Our Ref: FG/73/15/PL

Town & Country Planning Act 1990 (as amended)
Town and Country Planning (Development Management Procedure) (England) Order 2015
Application for Full Planning Permission

Development Additional works to approved planning application (ref: FG/141/14/PL). Works include a new masonry bin store enclosure, amended weatherboard, fascia, soffit cladding colour & new tiled roof.

Location The Bluebird Cafe South Drive Ferring

03 PROPOSED BLOCK PLAN
1000 Scale: 1:1000

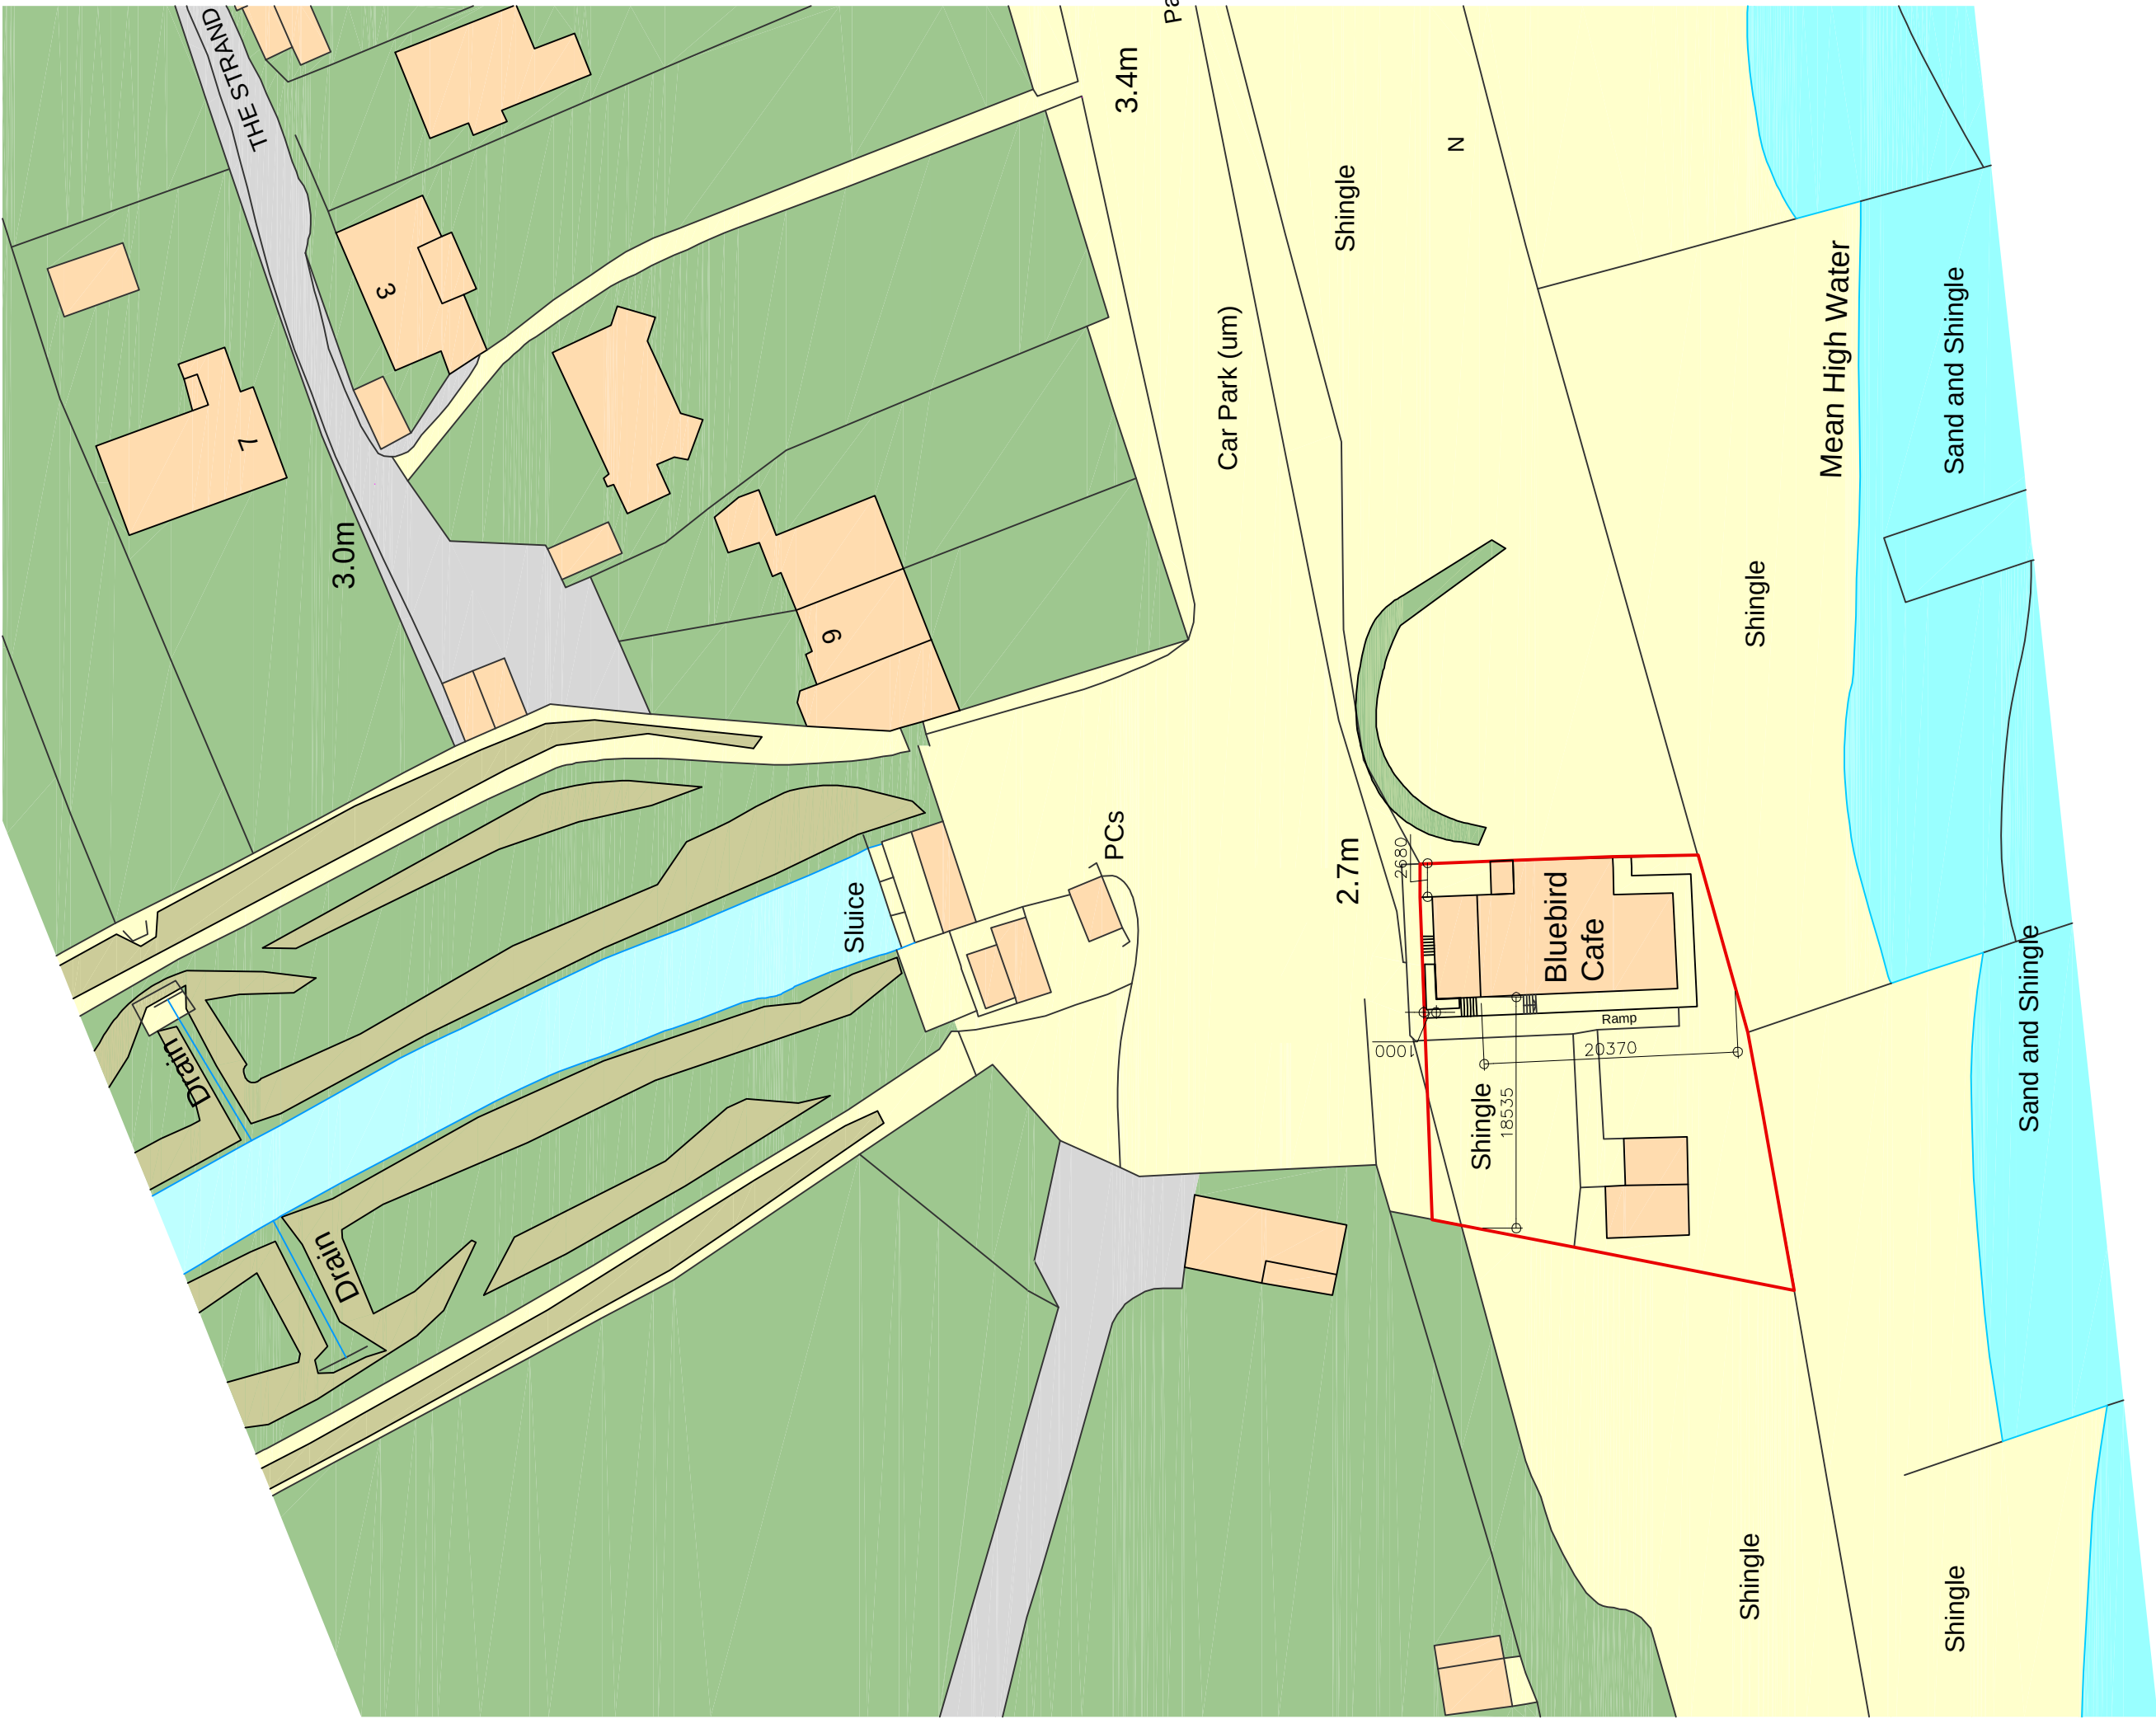
The block plan is still incomplete. The area of works need to be clearly highlighted with shading or hatching so that it is clear for the case officer and members of the public
